Our ref: PCS/120921
Your ref: APP/2011/3103
LPritchett19.06.12 ELS-3103

Town and Country Planning (Scotland) Acts
The Town and Country Planning (Environmental Impact Assessment) (Scotland) Regulations 2011
Planning application: APP/2011/3103
Full planning permission for Phase 1A of new settlement comprising 802 units, retail & commercial floorspace, civic buildings & associated landscaping, open space & roads infrastructure
Land to West of Chapelton of Elsick, Newtonhill, Stonehaven

Our ref: PCS/121733
Your ref: APP/2011/3103

Planning application: APP/2011/3103

DRAWING TITLE: Phase 1A Plan

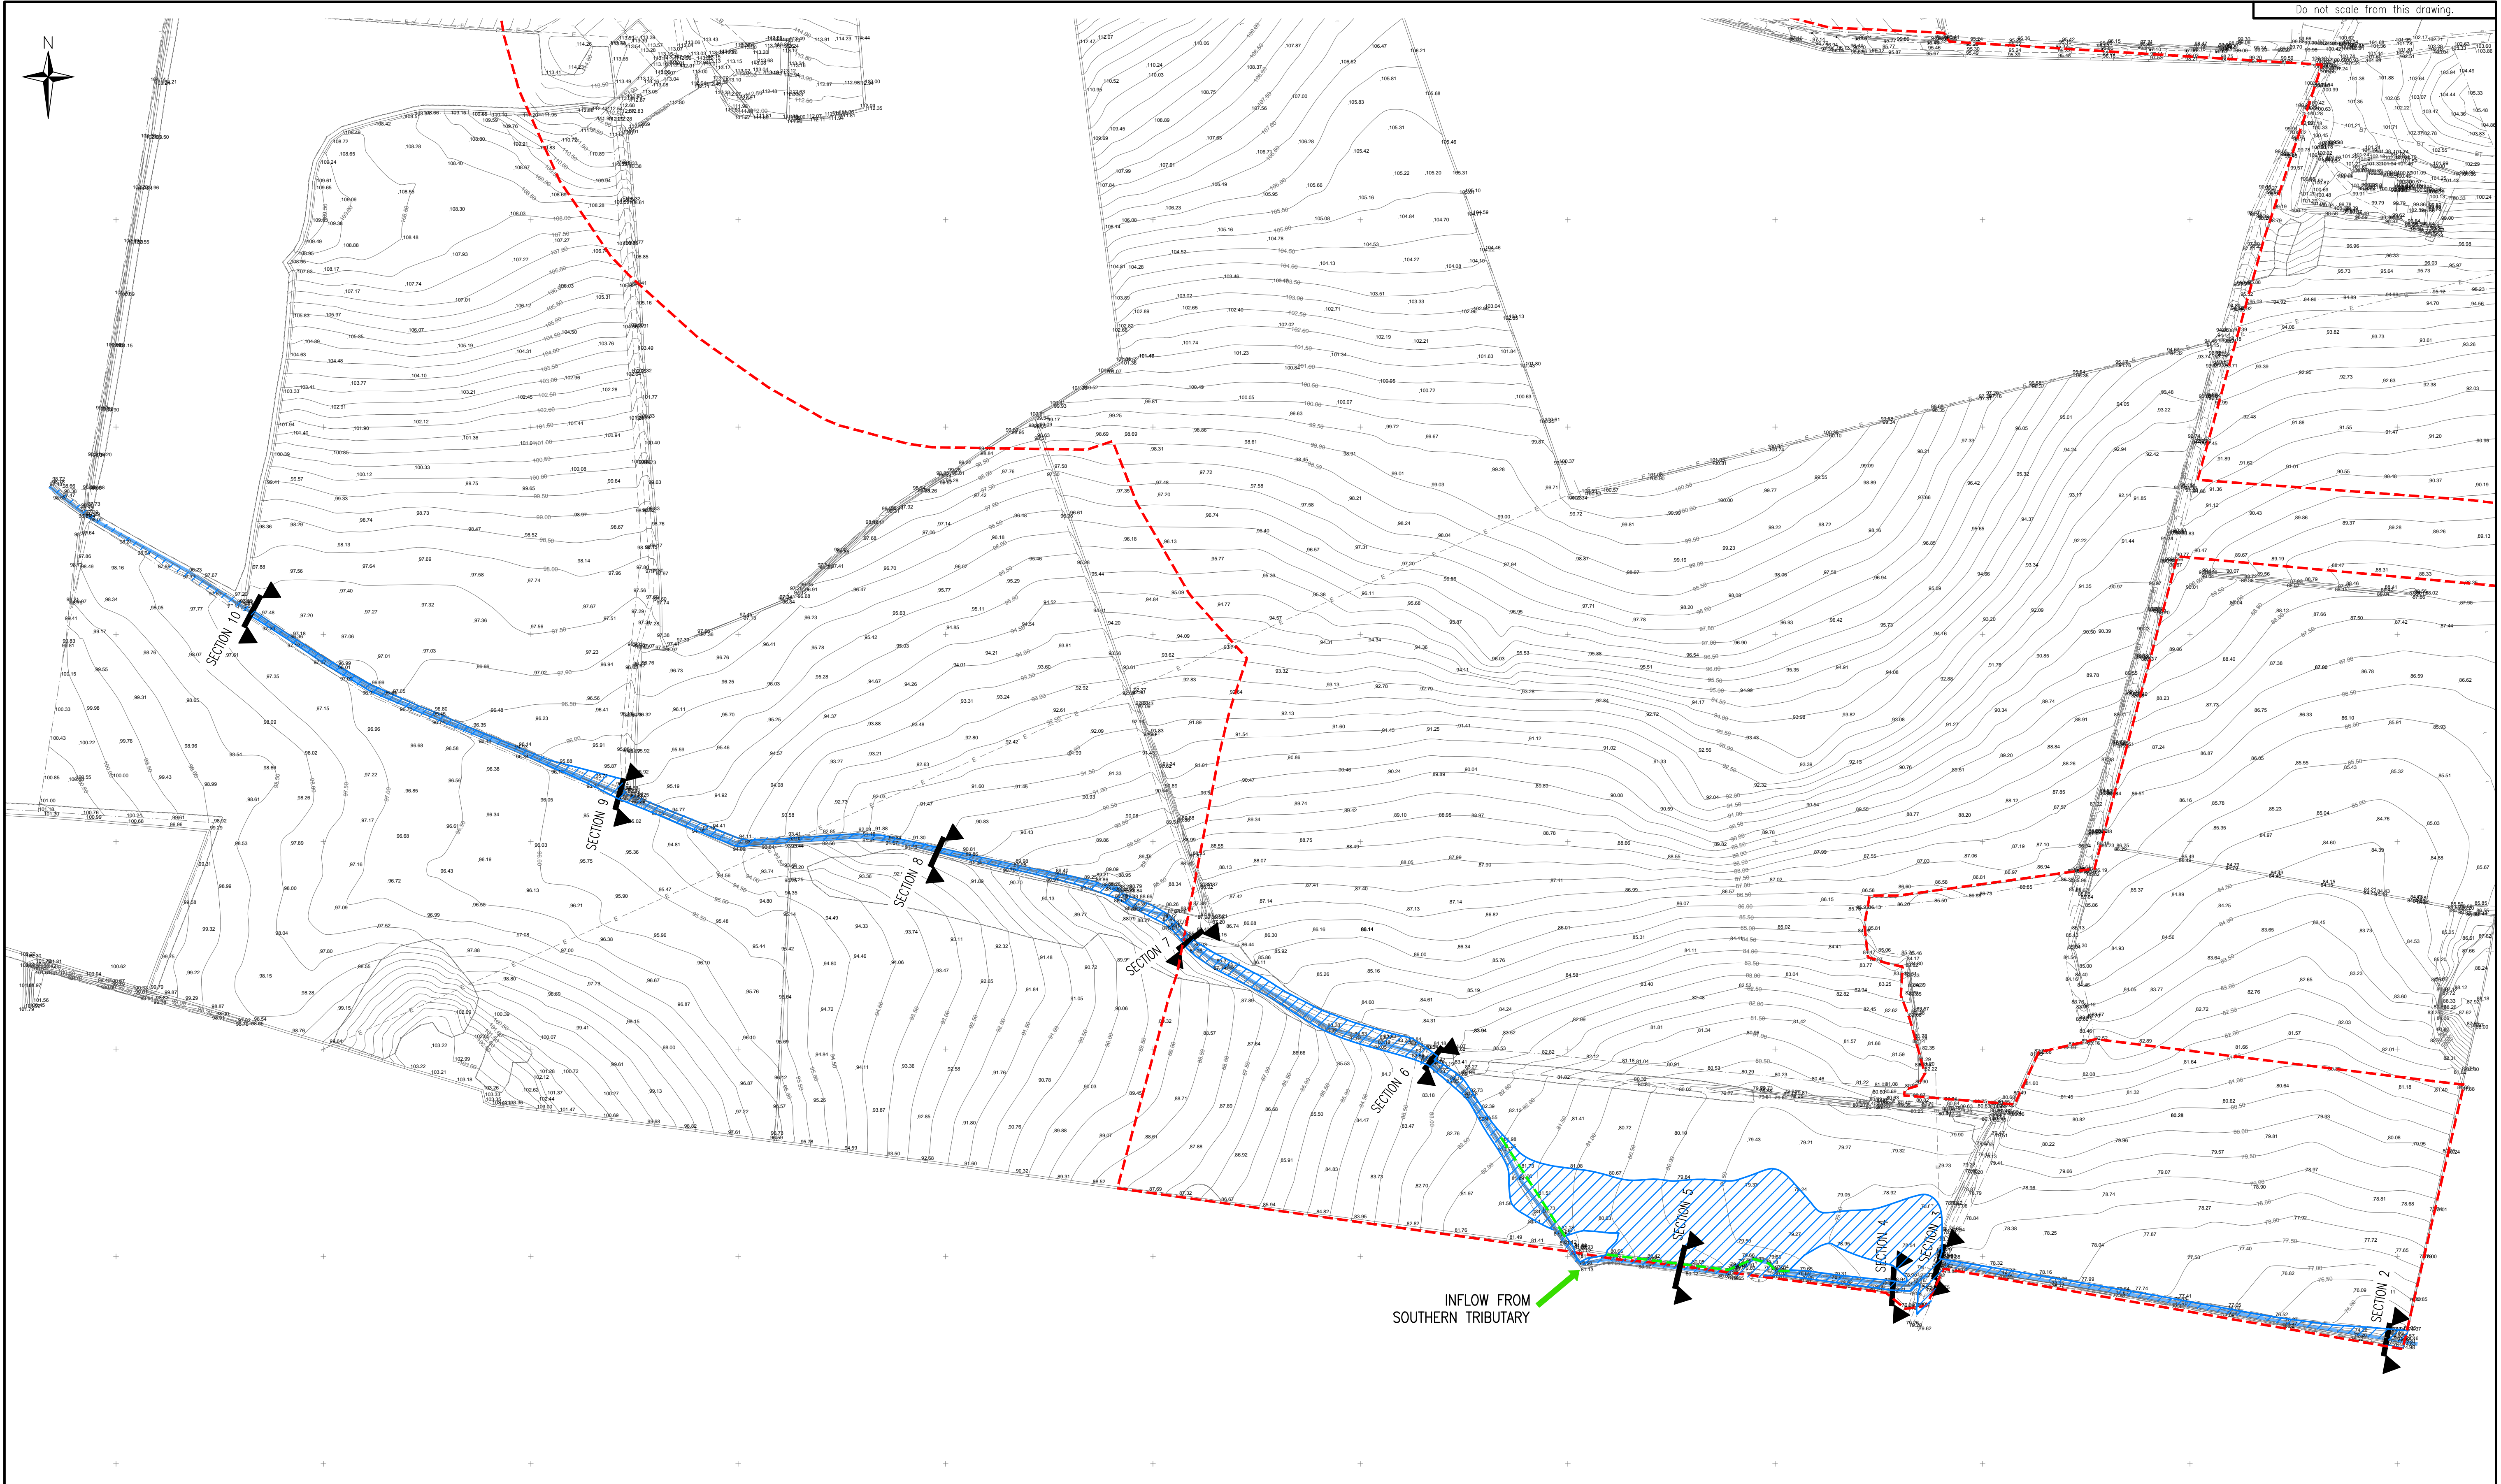
- New flood extent plan and masterplan to indicate the areas at risk of flooding interpreted from the revised FRA modelling results and that development is avoided in areas at significant risk;
- Confirmation that the SUDs basins are outwith the 1 in 200 flood envelope or that no embankments are proposed around them.

- 1.1 You advise that the masterplan has been amended to remove all building from area at risk of flooding and enclose a revised masterplan also showing the area at risk. We have reviewed the revised Flood Risk Assessment (FRA) (Elsick Development Company Chapelton of Elsie Phase 1A Detailed Flood Risk Assessment Final Report May 2012 Document Ref 72054/FRA/002 Fairhurst Issue 6 dated 17.05.12).

XS-6

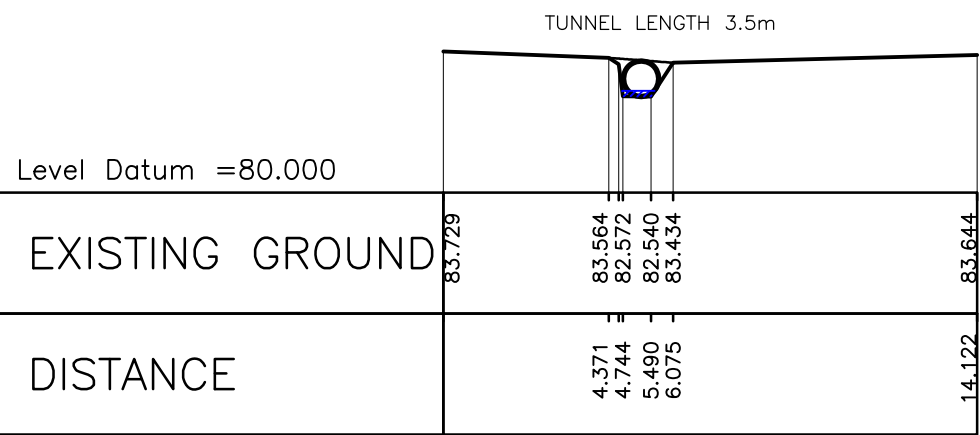
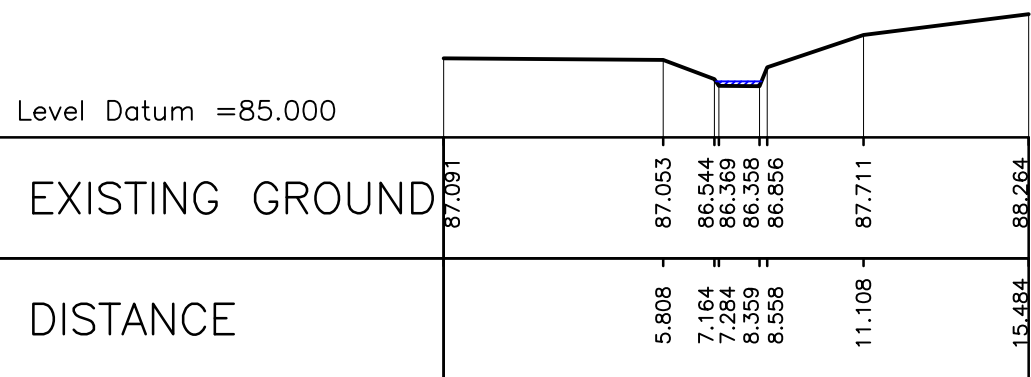
We would also request a **condition** on the planning application that no development is carried out until designs of the upgraded watercourse crossings (especially at cross section 6) are submitted and confirmed to convey the 200 year design.

- 1.4 We welcome that the majority of the development has been designed to be located outwith the areas at significant risk of flooding. However, the outputs of the hydraulic modelling in the area of the proposed steadings (cross sections 3 to 6) are ambiguous. The modelling, whilst indicating the inclusion of improved cross section data indicates that the flood levels will be 83.38m AOD between cross section 6 to 5 and 80.48m AOD between cross section 5 and 4. These levels do not appear to be interpreted onto the extent of flooding plan (ref 72054/2101 rev c) according to the surveyed heights. Whilst the gradient of the burn is generally steep, the area of the proposed steadings between cross sections 4 to 6 is flatter. A larger area than indicated is considered to be at risk of flooding and proposed development would still be within the functional floodplain and we require these areas to be avoided. The masterplan would need to be amended. Further clarification should be provided with regards to this and we would re-iterate that the avoidance approach should be a key design principle particularly given the significant masterplan area available outwith an area at significant risk of fluvial flooding.

Drawing Title:
EXTENT OF FLOODING
PHEPPIE BURN
PHASE 1A

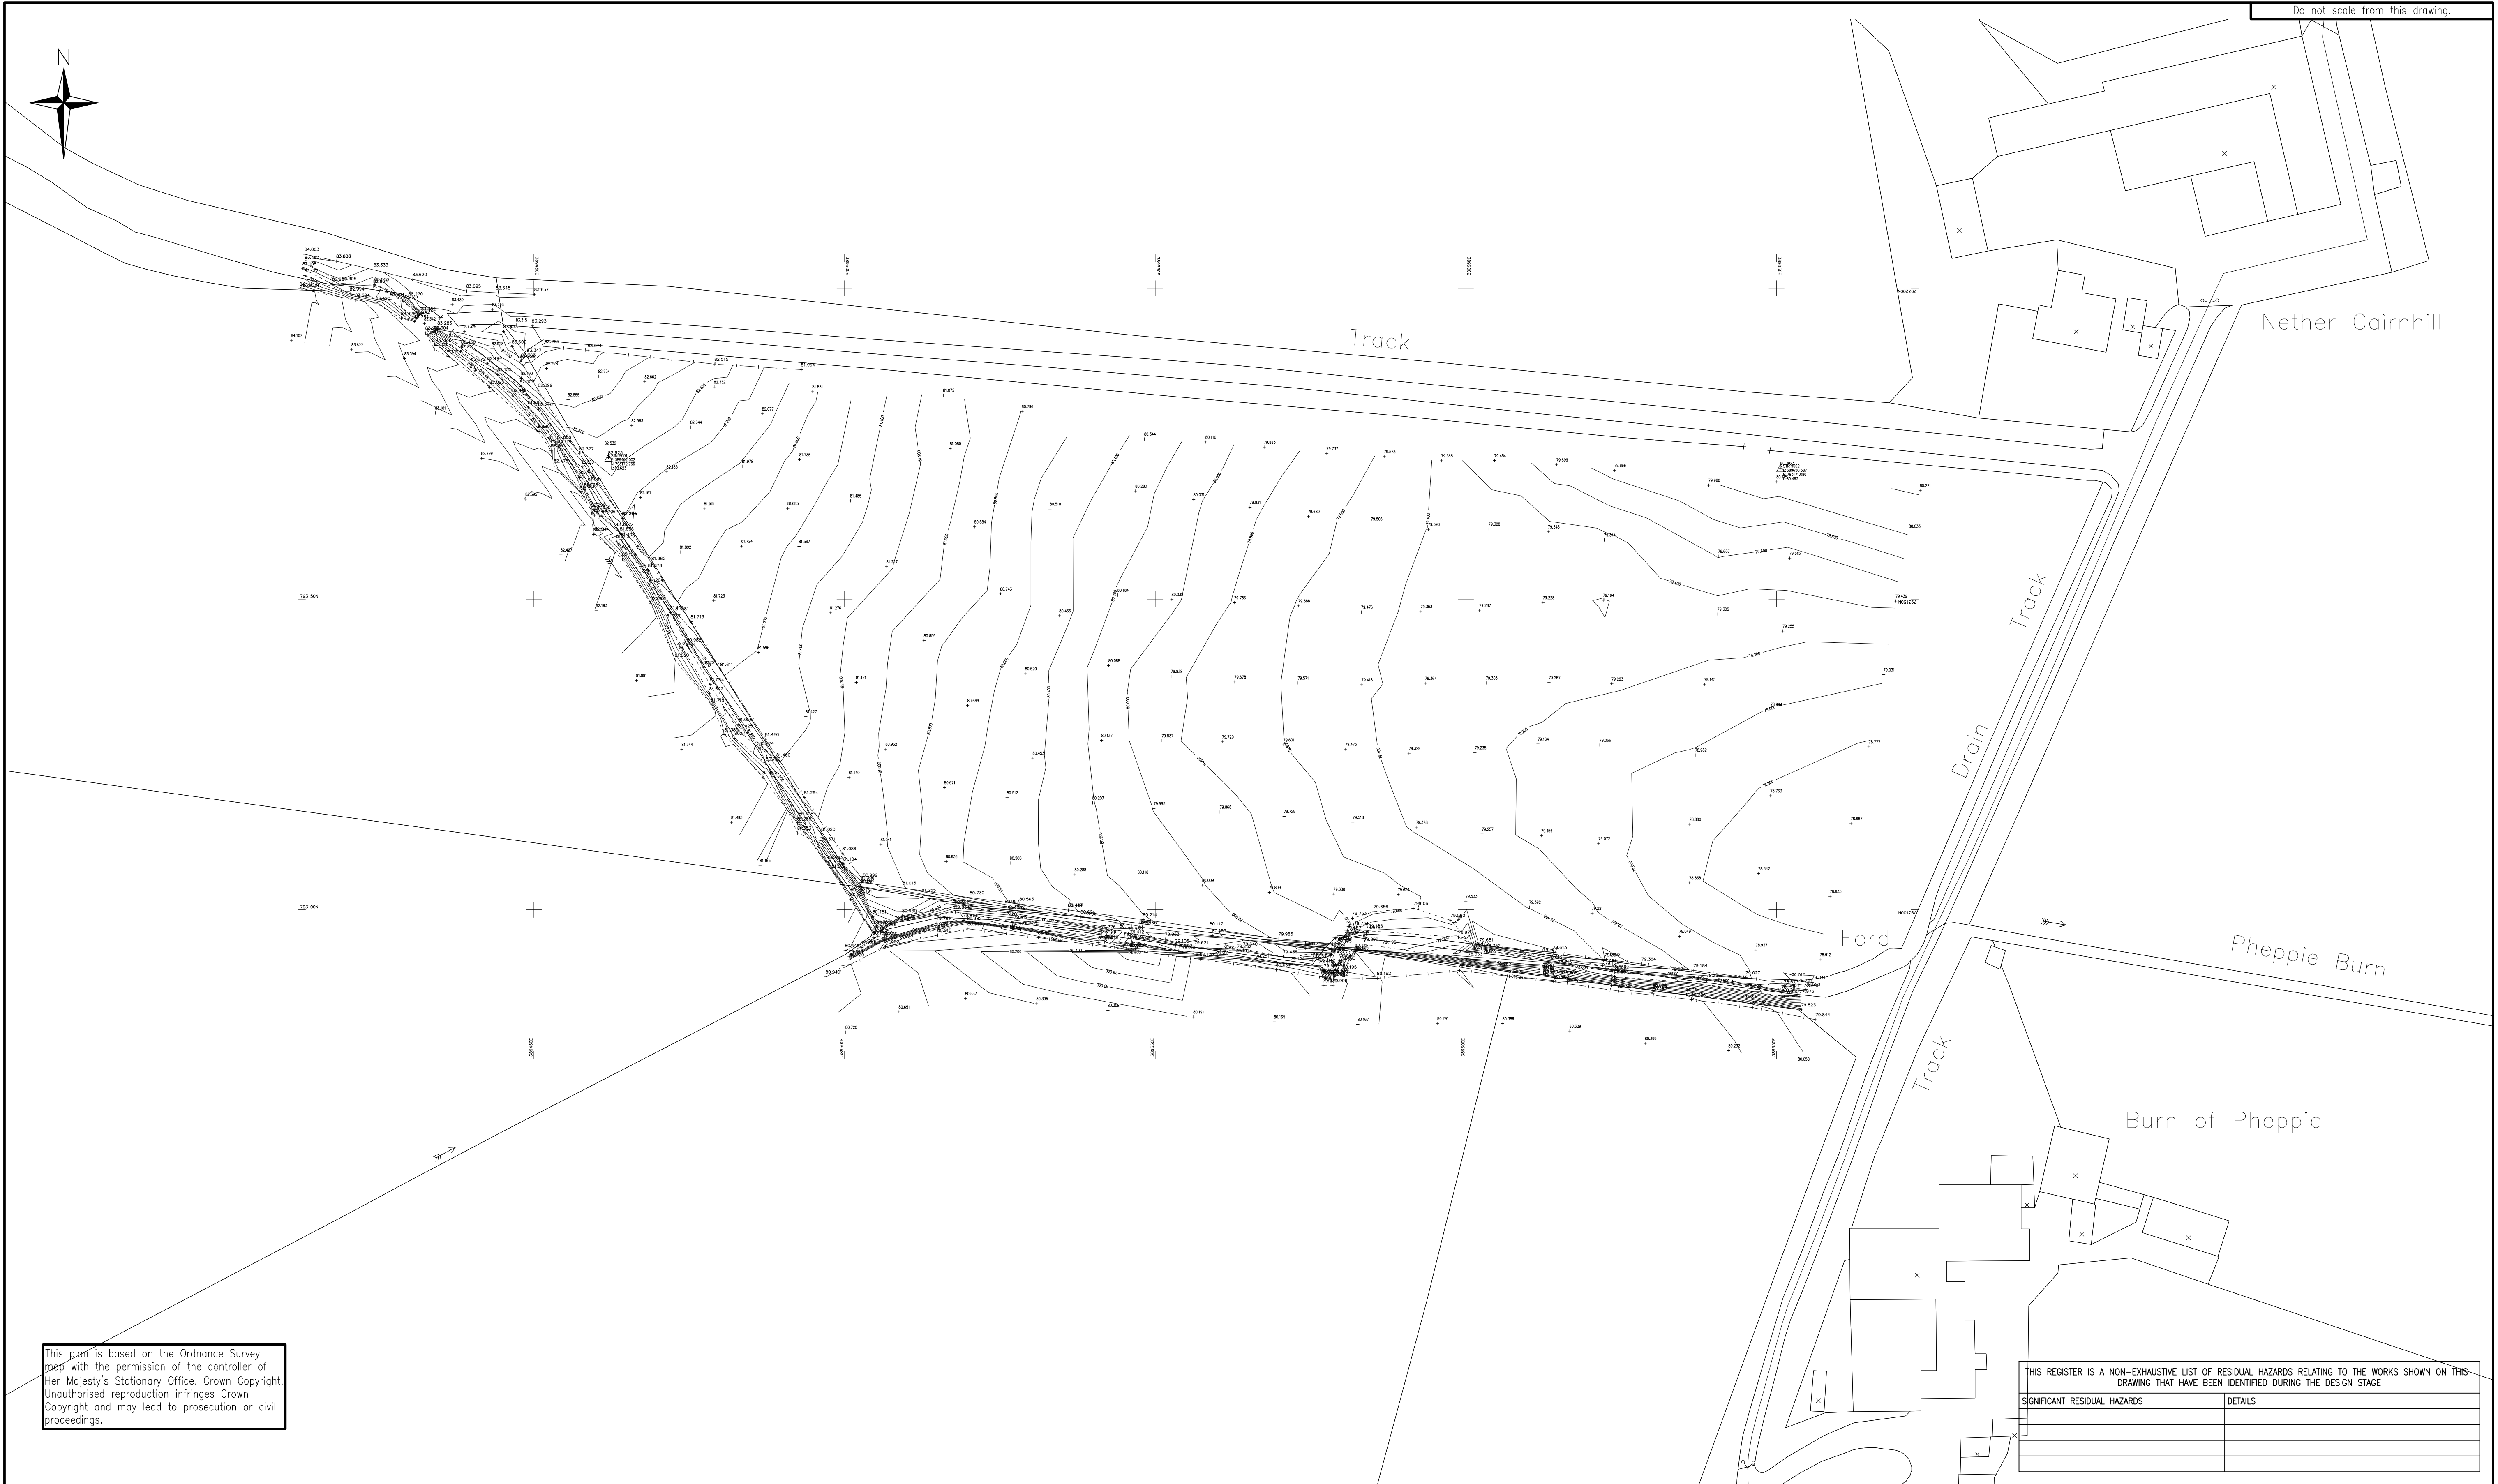
- 1.5 We also have concerns that several of the steading plots (if buildings area shown to be outwith the functional floodplain) have either a large portion of garden ground at risk of flooding or are cut by the Pheppie Burn (with garden ground on one site and the property on the other). We would ask for comment from the Local Authority and Flood Prevention Authority on acceptability of these garden grounds being included within house plots and how access to the opposite bank will be gained for the property cut by the burn. We note

We still have concerns regarding the extent of garden grounds that will be at risk of flooding, although are pleased to note that all properties are located outwith the functional floodplain. Your email states that proposed planning conditions are being worked on, and we look forward to being consulted on those proposed as a way to address this issue. One property in particular is very close to the area at risk of flooding, and has a significant area of garden at risk of flooding.
